**Applicant:** Paragon Fleet Solutions Ltd

**Proposal:** Discharge of condition 5 (travel plan and draft routeing agreement) of 18/02169/F

- 2.2. The application was submitted on 29<sup>th</sup> August 2019 (within the three-month timescale) and was supported by a location plan, Ref: P18 1596 01 and Workplace Travel Plan (Ref: BR-702-0001).

Figure 4-3 Current and Proposed Public Rights of Way

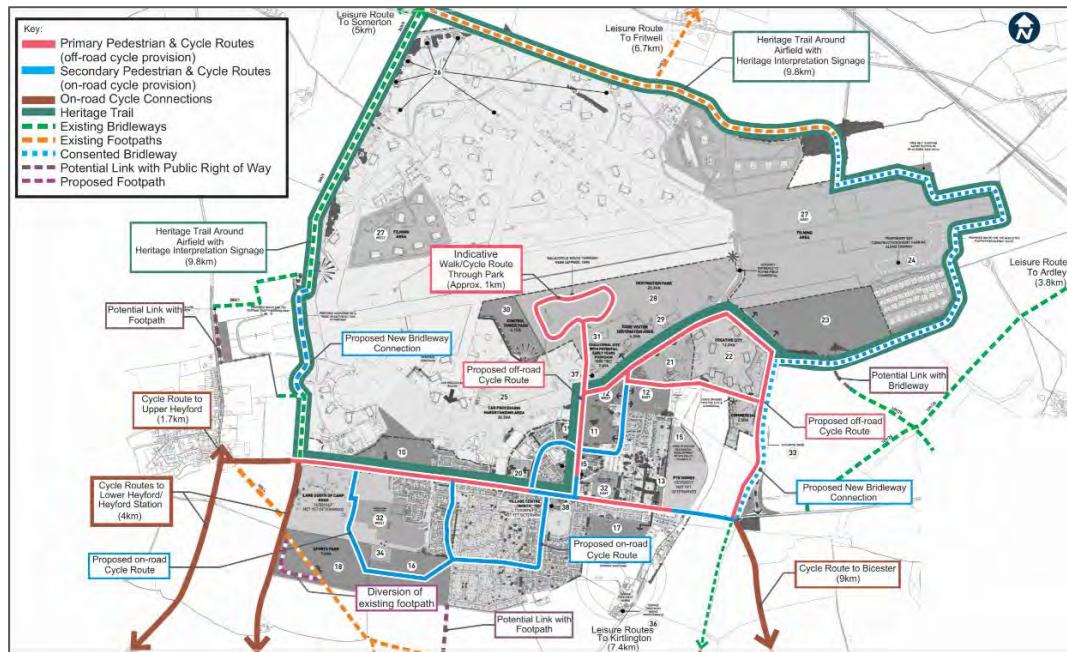
Section 4.3 of the Travel Plan references the network of public rights of way in the area and the value of these routes for walking and cycling journeys once the walking and riding network as illustrated in figure 4.3 is delivered. However, the site owners have so far failed to meet the current and overdue requirements to reinstate Aves Ditch and Portway bridleways through the site and along Chilgrove Drive. This means that their potential for use as sustainable travel options is not relevant in relation to this Travel Plan. Given the direct connection between the whole site, the reopening of Aves Ditch and Portway, and this application, the

Figure 4-5 - Strava Heat Map

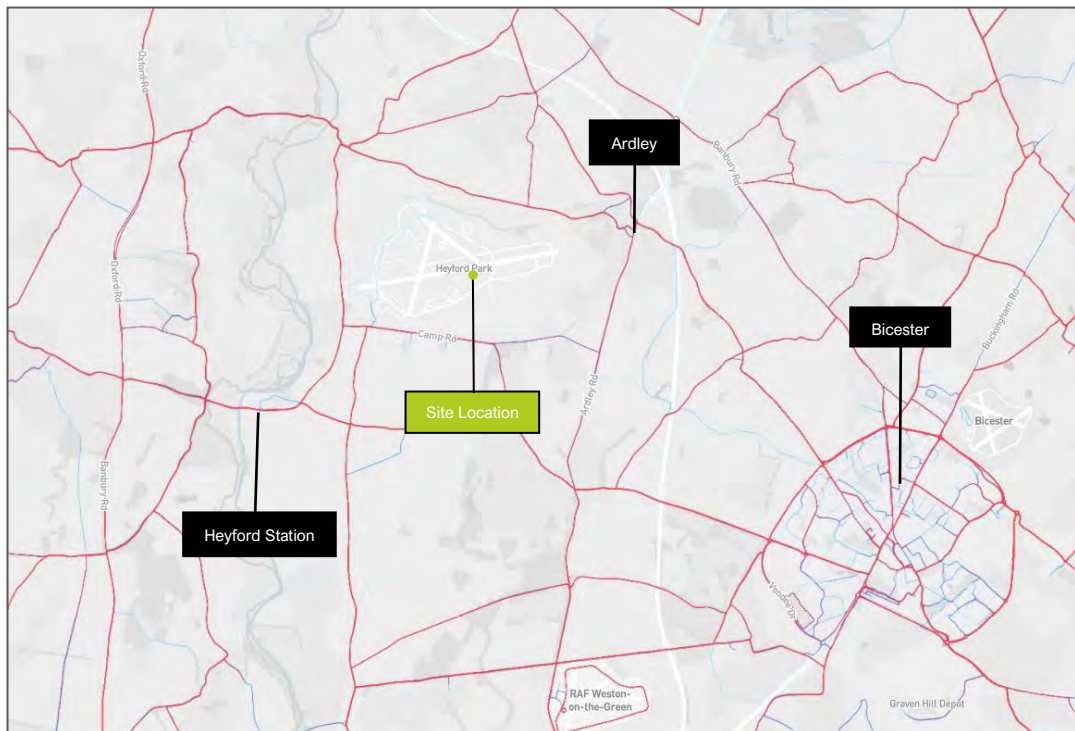
- Paragraph 4.3.16. It is not stated what a Strava Heat Map is. Figure 4.5 therefore has no meaning;
- Paragraph 4.3.32. The accessibility to bus travel for 14% of staff is considered low;

Figure 9-1 Car Share Opportunities

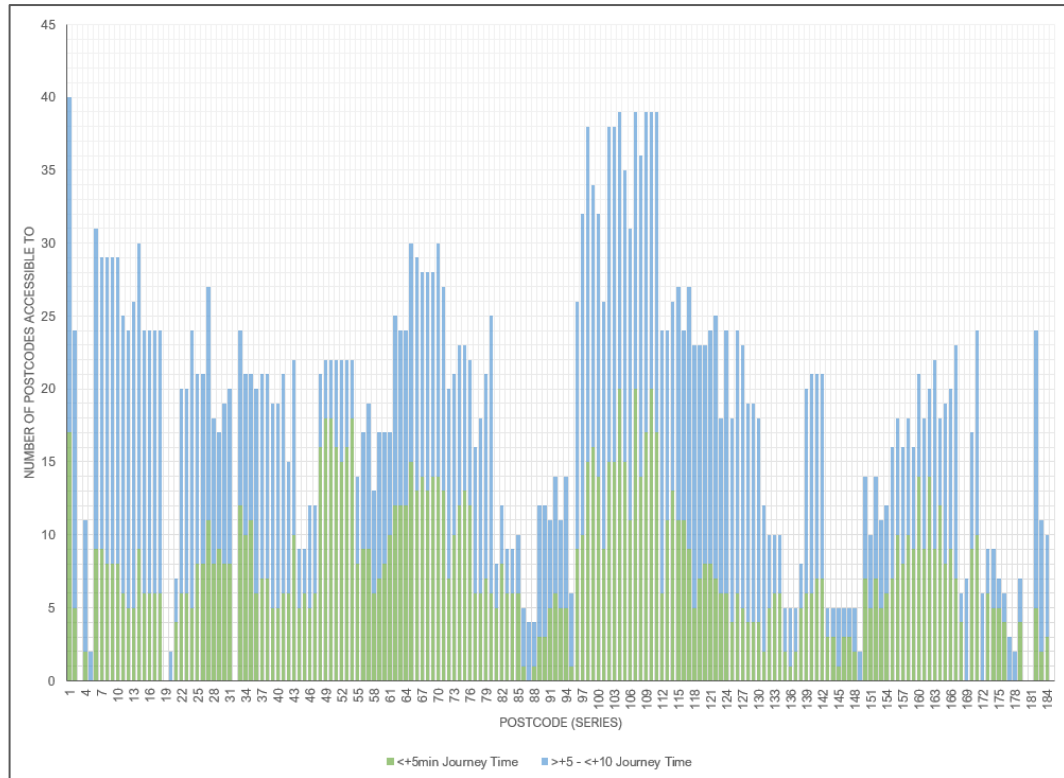
- Paragraph 9.7.1, d) It is not stated how car sharing will be rewarded;
- Paragraph 9.7.2, e) It is not clear how car sharing can reduce absenteeism;
- Figure 9.1. It is not clear what this figure is demonstrating;
